From: Paul Cann
Sent: 28 June 2017 14:15
To: Planning.Responses
Subject: RE: Planning Consultation on AL/67/17/DOC

AL/67/17/DOC

Land West of Westergate Street & East of Hook Lane
Westergate PO20 3TE

Application for approval of details reserved by condition imposed under planning permission AL/107/16/RES relating to condition No. 4 (Access & maintenance of any watercourse or culvert (piped watercourse) crossing or abutting the site)

Drawing No. BSO/E4462/452 E

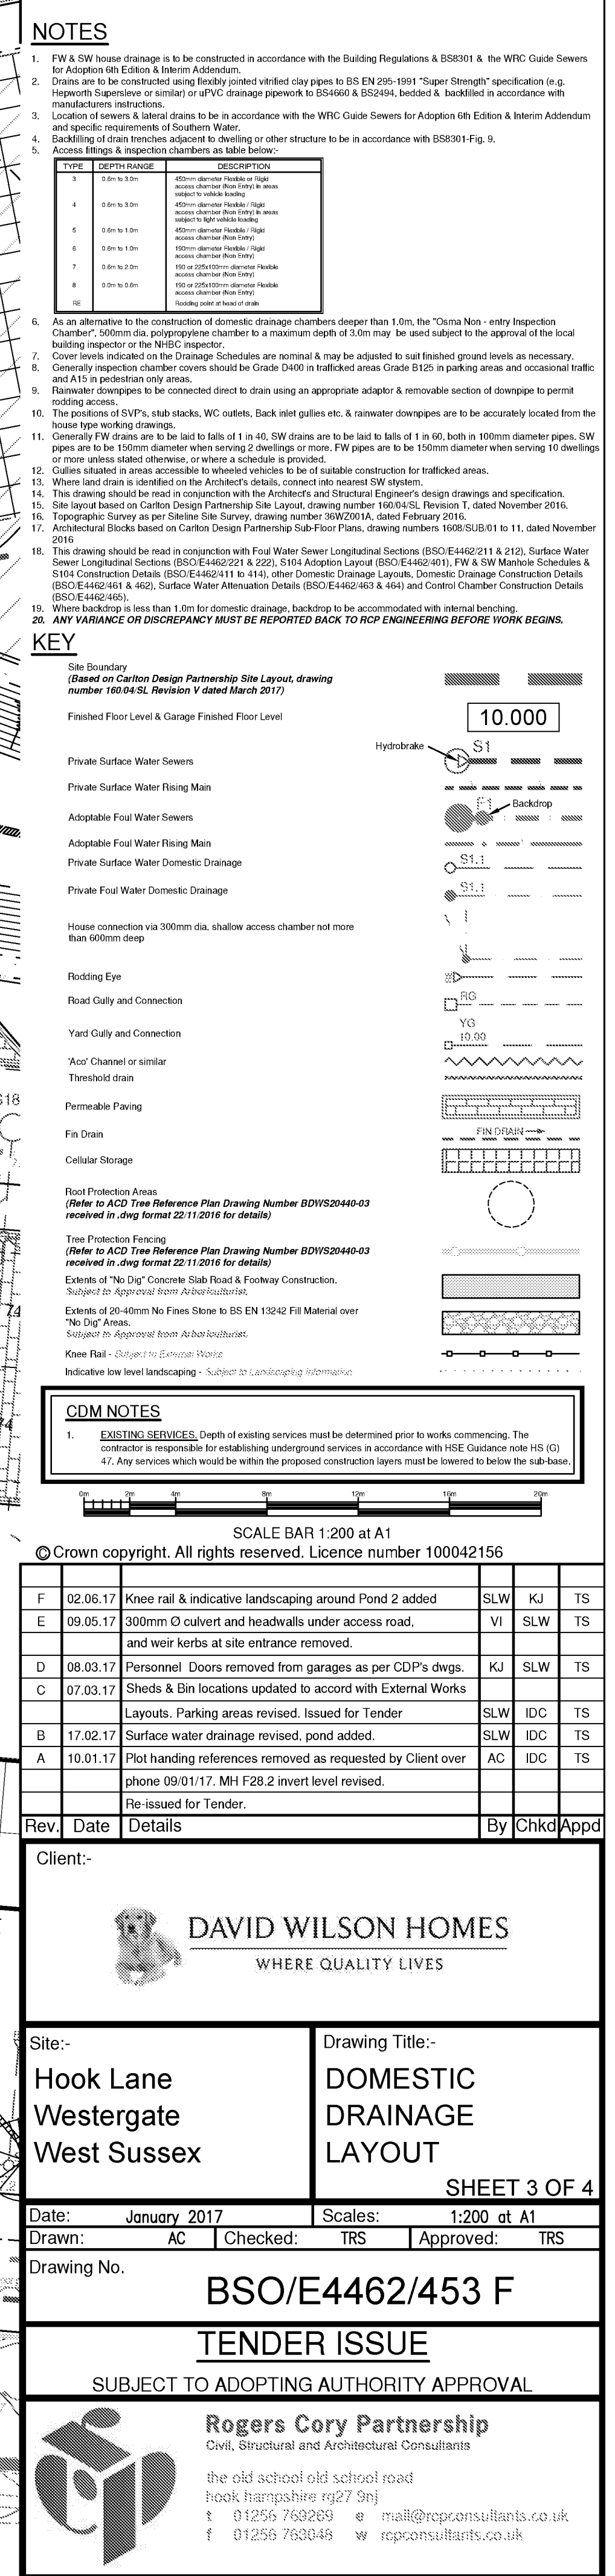
The deeds drawing needs to show a demountable fence along the western boundary of the easement strip. Please could the applicant revise accordingly. Please note that drawing BSO/E4462/454E shows this but it has not been submitted as part of the DOC application.

Please note that the requirement for the demountable fences will need to be written into the deeds of the relevant individual properties on the development, as will a 'deed of easement' to ensure access through the gates/over the private parking spaces of plot 66, at the entrance to the easement strip.
